**KIRKLEES METROPOLITAN COUNCIL
INVESTMENT & REGENERATION SERVICE**

Reference No:	2023/62/91304/E
Site Address:	9, Holmfirth Road, Shepley, Huddersfield, HD8 8BB
Description:	Erection of two storey extension and alterations
Recommending Officer:	Edward Cheseldine

DECISION - REFUSE

Officer Report

Project No 2835	Drawing No (100)02	B
---------------------------	------------------------------	----------

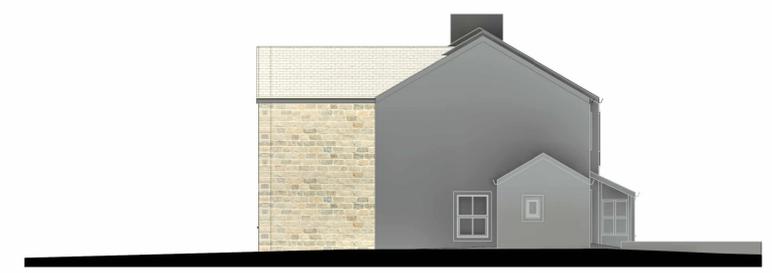
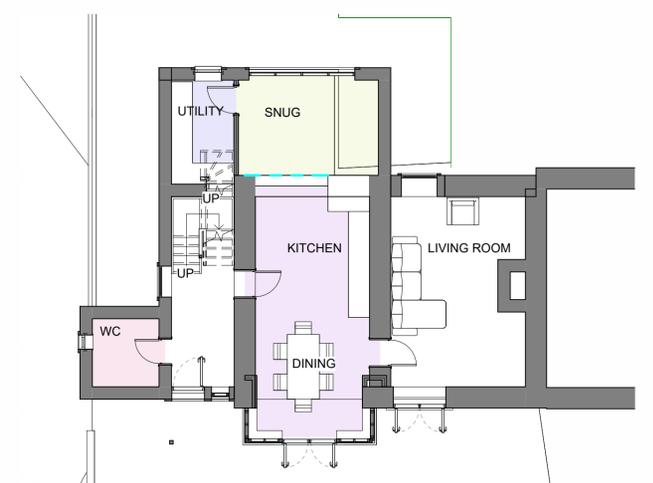
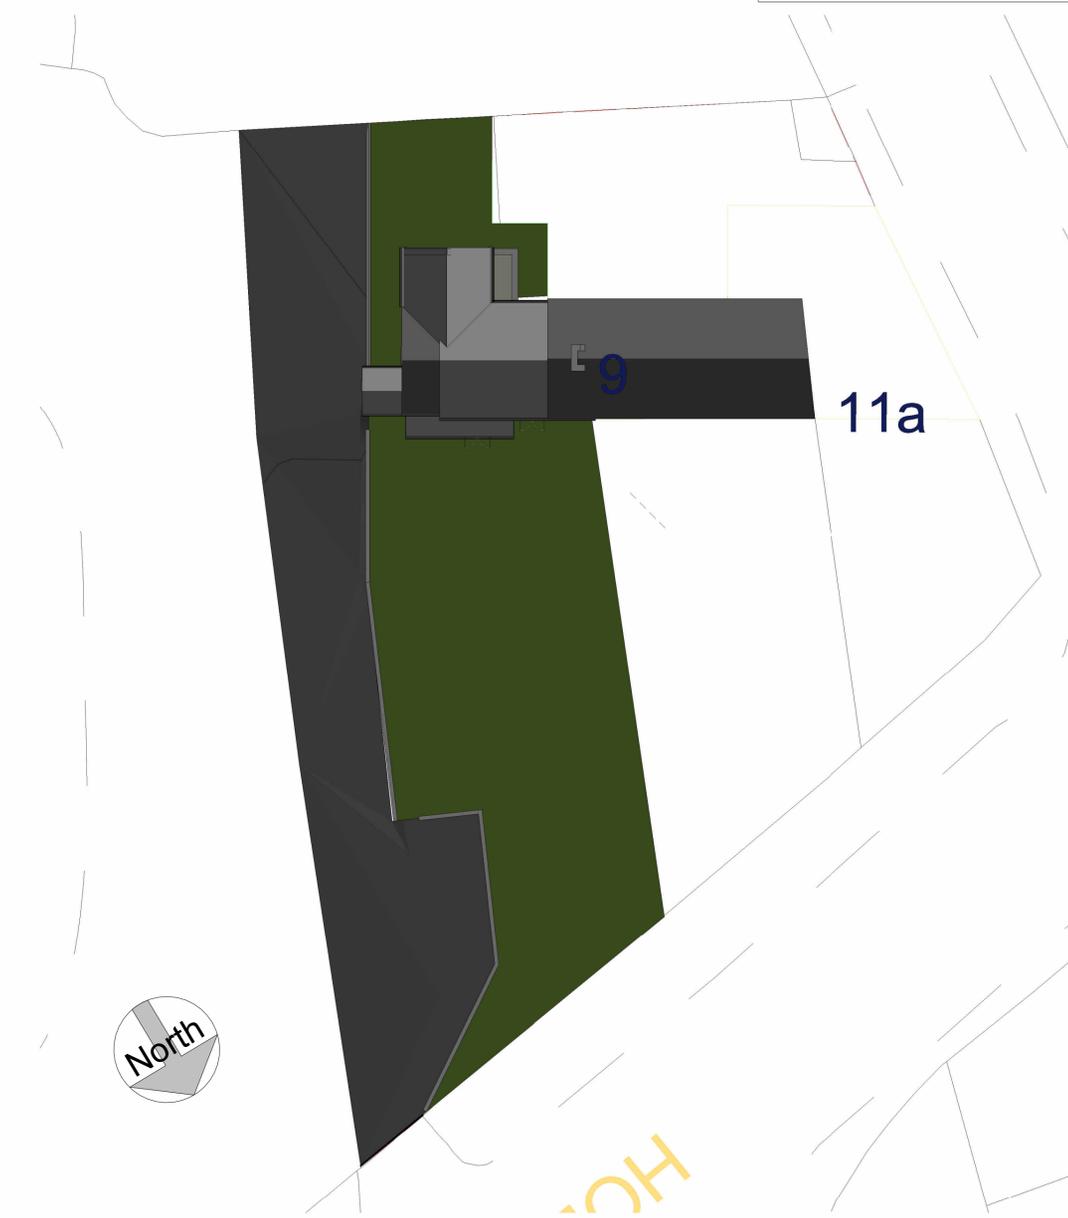
The extension would project ~2.85m from the existing rear elevation, to a width of ~6.55m. The first-floor will be stepped in to a width of ~5.00m. The extension will reach a height of ~4.70m to the eaves, to a maximum height of ~6.30m including the gable end roof.

In terms of size measurements, the proposed extension meets the above criteria, by projecting less than 3.00m and being situated over 1.50m from the property's boundary shared with the adjoining dwelling.

The Planning Practice Guidance (PPG) sets out that “openness is capable of having both spatial and visual aspects” – in other words, the visual impact of the proposal may be relevant. In this case, whilst the extension would be located to the rear of the dwelling, the impact of the proposal by virtue of the introduction of an additional rearward projection must be considered. The terrace row benefits from a simple rectangular form whilst the rear elevation of No. 9 maintains its original historic features. The introduction of a rearward projection would produce a cross-gable feature which departs from the existing architectural features presently found on the terrace row. Although the projection of the extension is modest, when cumulatively assessed with the existing side extension, two out of three of the original elevations would be covered dominating the appearance of the host dwelling. Due to the size of extension, the roof style would produce a ~5.30m rearward roof ridgeline which would appear as a large addition to the structure due to the scale of the dwelling.

The proposal would be built upon land that currently has a combination of loose gravel and ground material of which there is no greenery left. Satellite imagery shows there to be a surface change between 2012 & 2018 for which there is no planning permission present. The extension will encroach upon this rear area of former green space to dimensions of 6.55m (W) x 2.85 (L) x 4.50 (H), impacting its open character.

The proposal therefore fails to comply with Policy LP57(a) of the Kirklees Local Plan and the aims of Chapter 13 of the NPPF as the original house would not remain the dominant element when considering the visual impact. The proposals also fail to comply with Policy LP24 of the Kirklees Local Plan (a) in terms of the form, scale and layout and (c) as the extension would not form a subservient addition to the property in keeping with the existing building; nor advice within the House Extensions and Alterations Supplementary Planning Document, specifically KDP1 with respect Local Character, taking into account the terrace row. In addition, the proposal would not accord with KDP2 with regards to the impact on the original house as the design of the extension is neither well balanced, proportionate or sympathetic to the existing house or the aims of chapter 12 and 13 of the National Planning Policy Framework.

The proposed extension would form disproportionate additions to the dwelling, which would constitute inappropriate development in the Green Belt. Furthermore, the level of development proposed together with previous extensions would not be visually subservient to the original house and would be harmful in terms of the appearance and character of the dwelling. To permit the proposals would be contrary to policies LP24 and LP57 of the Kirklees Local Plan, advice within the House Extensions and Alterations Supplementary Planning Document and advice within chapters 12 & 13 of the National Planning Policy Framework.

1. The cumulative impact of the existing and proposed extensions would detrimentally alter the character of the original building and adjoining terrace row to an extent that harms the historic character and design of the dwellinghouse. To permit the proposals would be contrary to Policies LP24 and LP57 of the Kirklees Local Plan, advice within the House Extensions and Alterations Supplementary Planning Document and with chapters 12 & 13 of the National Planning Policy Framework.
2. The cumulative impact of the existing and proposed extensions would be disproportionately large in relation to the original part of the building and represents inappropriate development, which is harmful to the Green Belt and the visual amenity of the area. The proposed development is therefore contrary to Policy LP57 of the Kirklees Local Plan and paragraph 149c of the National Planning Policy Framework.
